From: Anita Gardner Anita.Gardner@arun.gov.uk
Subject: RE: 57 River Road, Littlehampton - Response to Pre-Application Advice
Date: 1 June 2021 at 13:39
To: Kerry Dames kerry@

1908-P-100-2 BLOCK PLAN - 1:500 @ A3

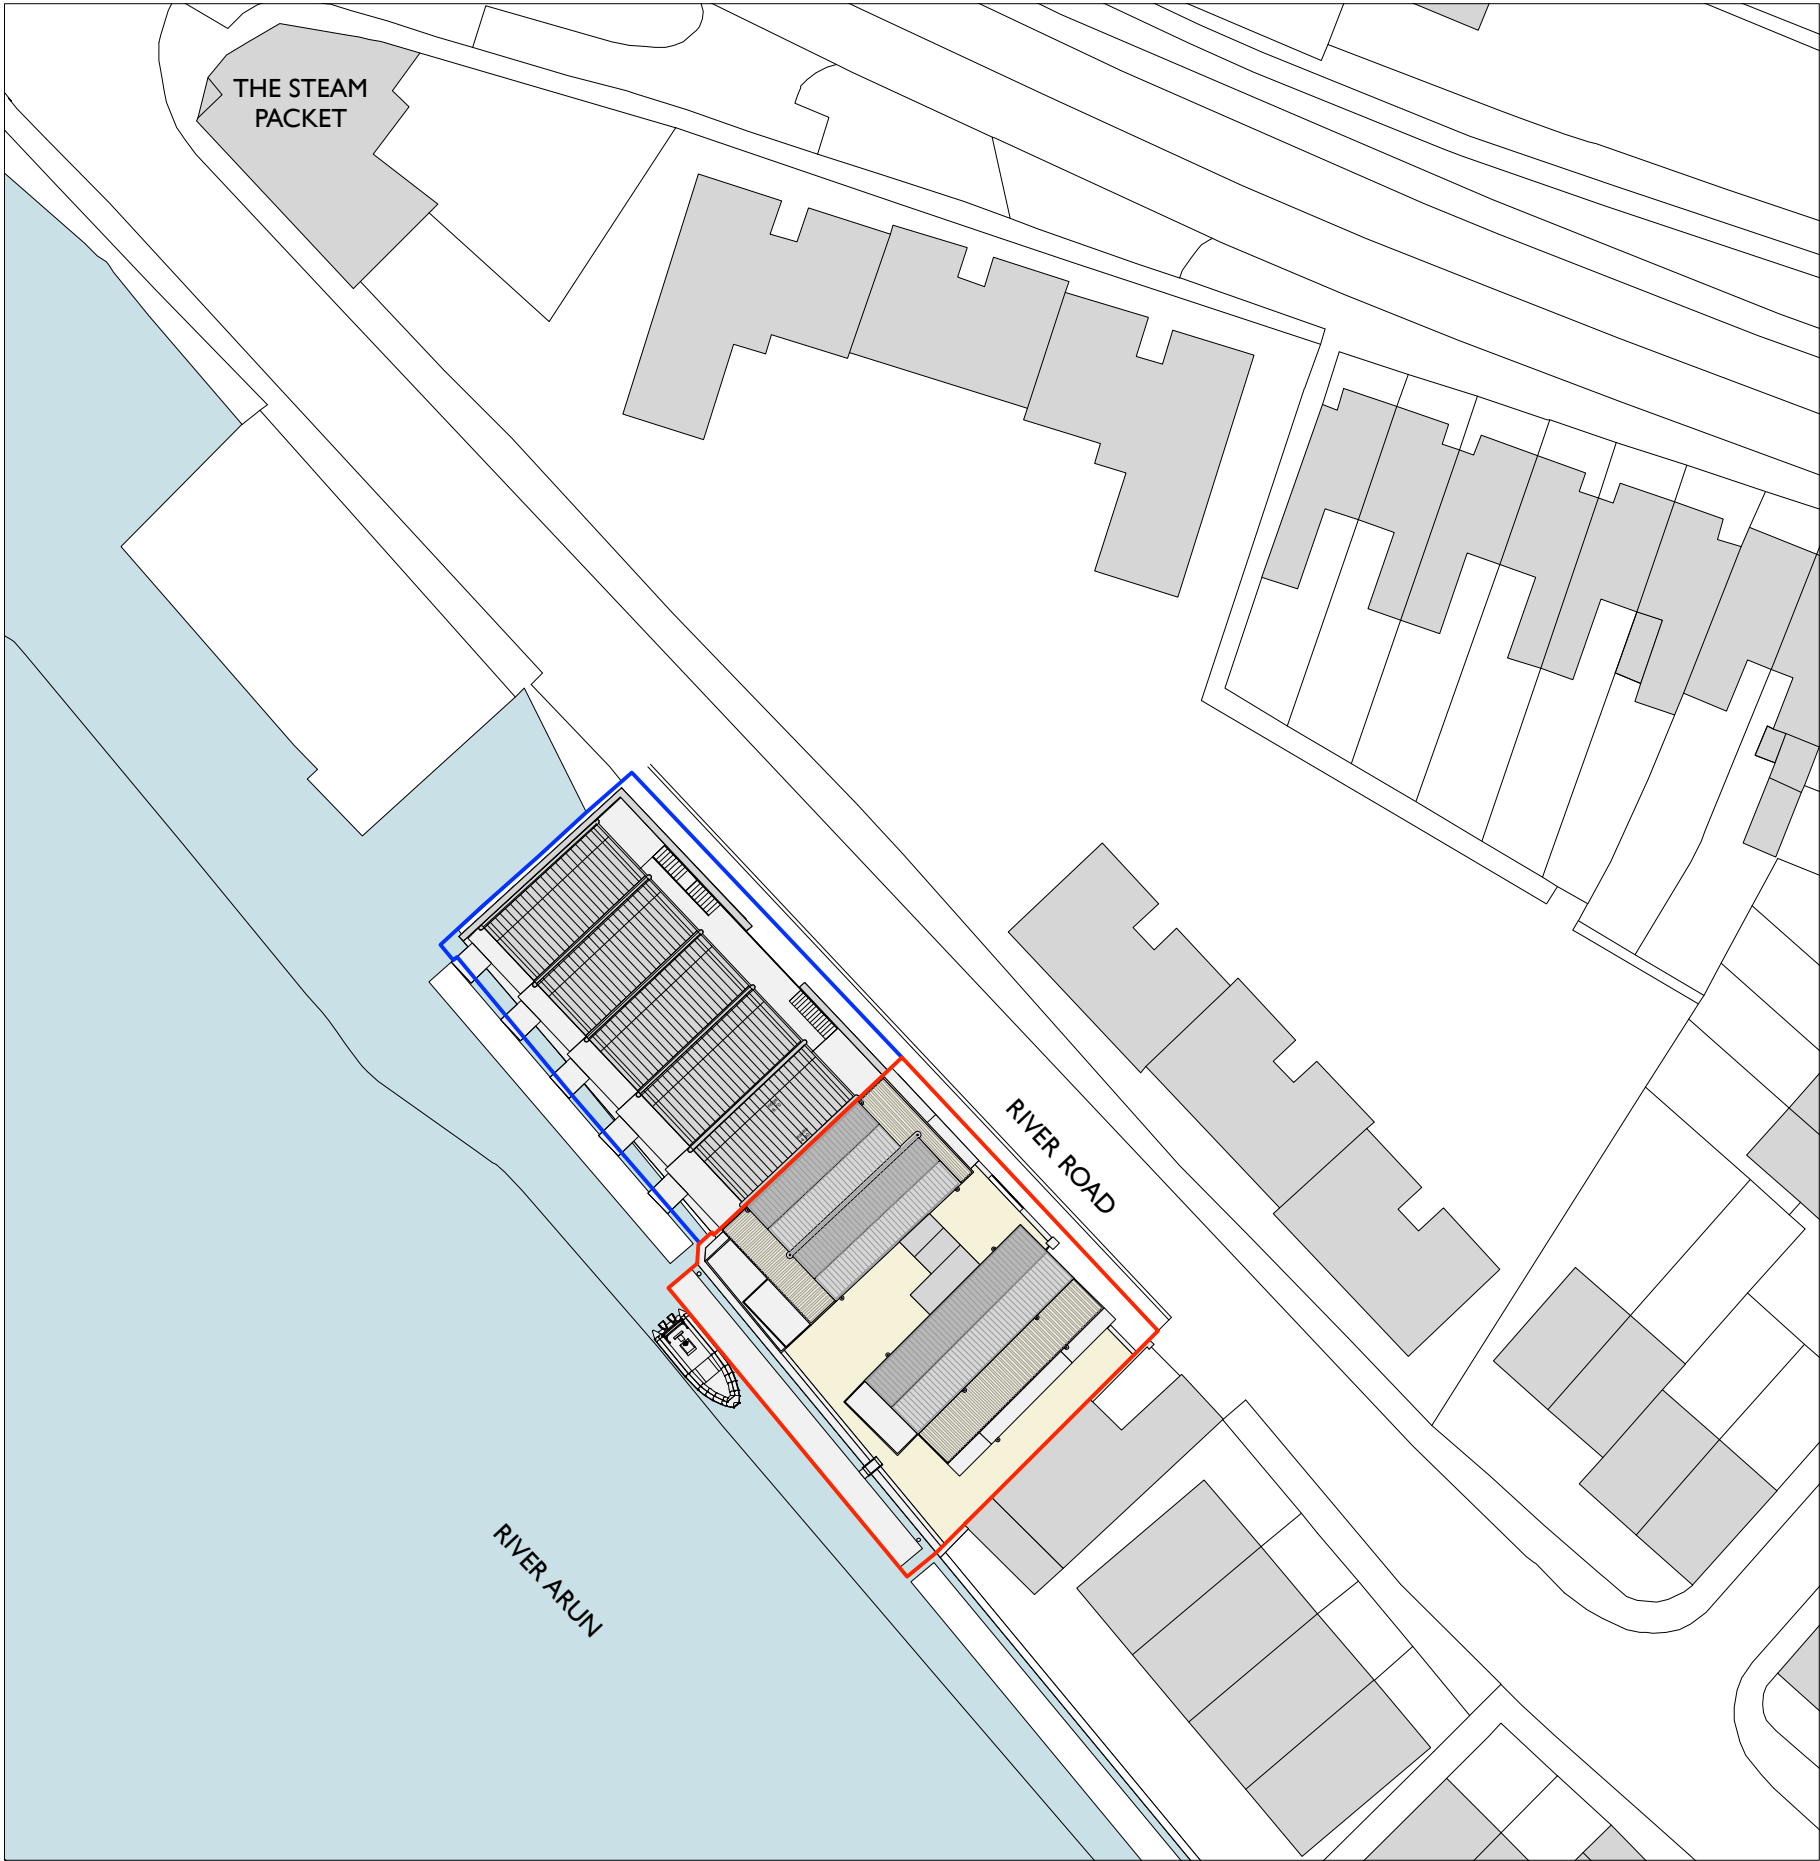
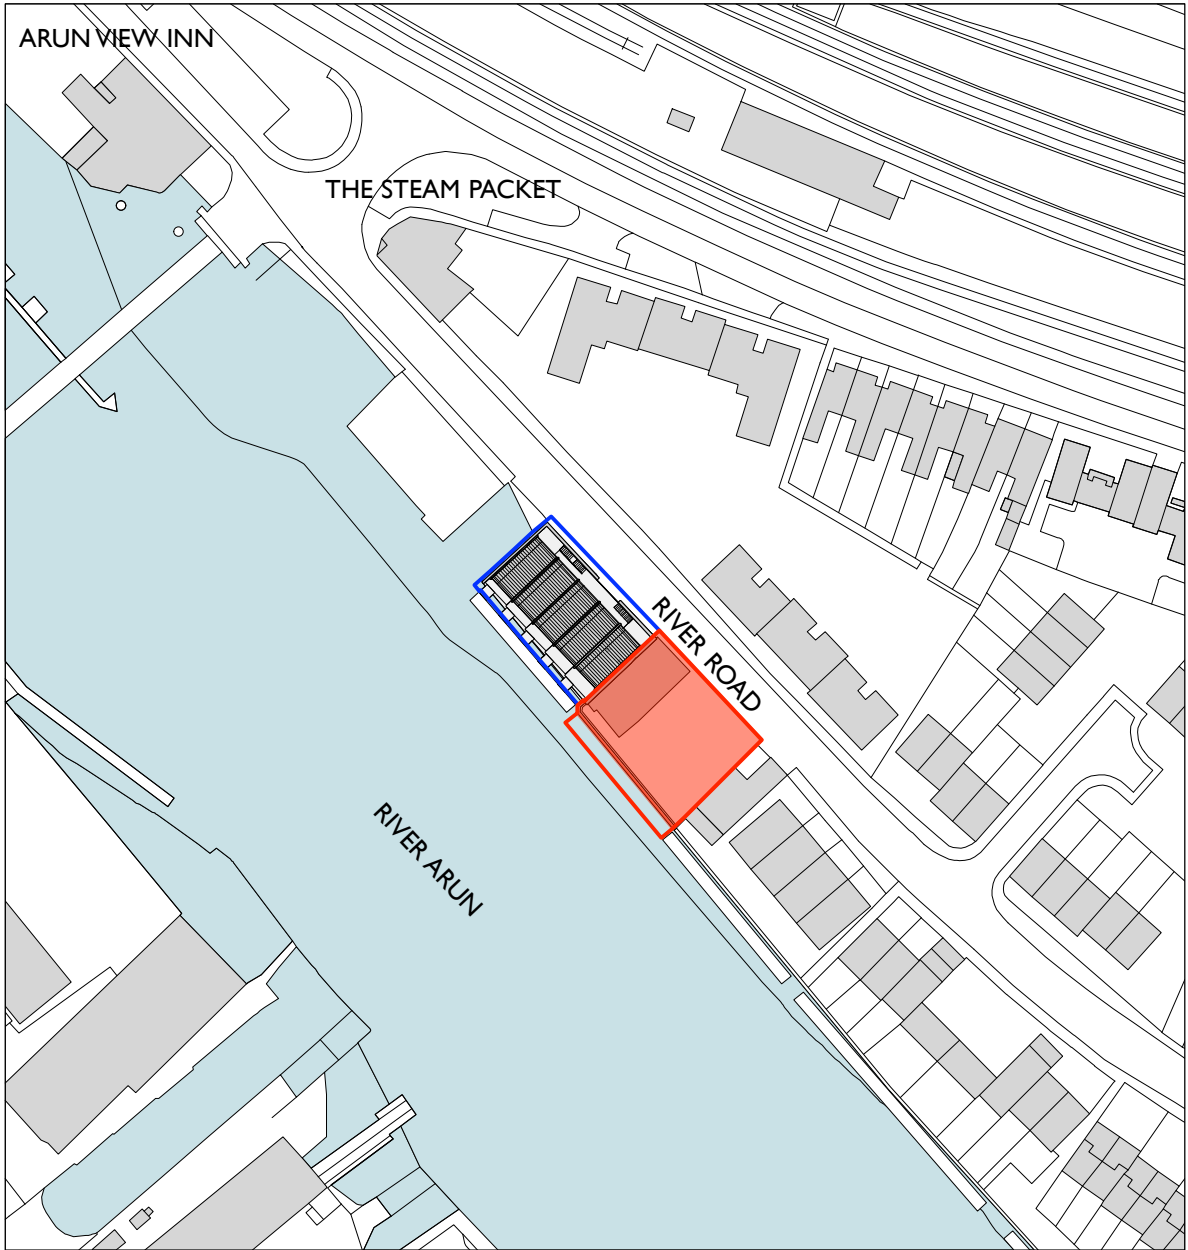
The Conservation Officer has reviewed the revised plans and understands the point re the gap between the two new buildings and found it helpful to understand that both the lift and stair core is designed as fully glazed, as this was not fully clear to him.

I note the increase in separation distances of 0.5m which is welcomed.

You will see that in considering the suggestion of increasing the gap between the southern building and the neighbouring non-designated heritage asset (49 River Road), we have arrived at an option which increases the separation by half a metre:

- Slightly reduced space between the southern and northern wings - 0.3m
- Reduced the width of the southern block - 0.2m

We also considered the suggestion of using space behind the lift shaft. The lift and stair core is designed as fully glazed to be as transparent as possible to maintain the sense of space between the blocks and views through to the riverside. We are keen not to compromise this and feel fractionally narrowing the space is a better option than adding to the footprint behind the lift shaft.
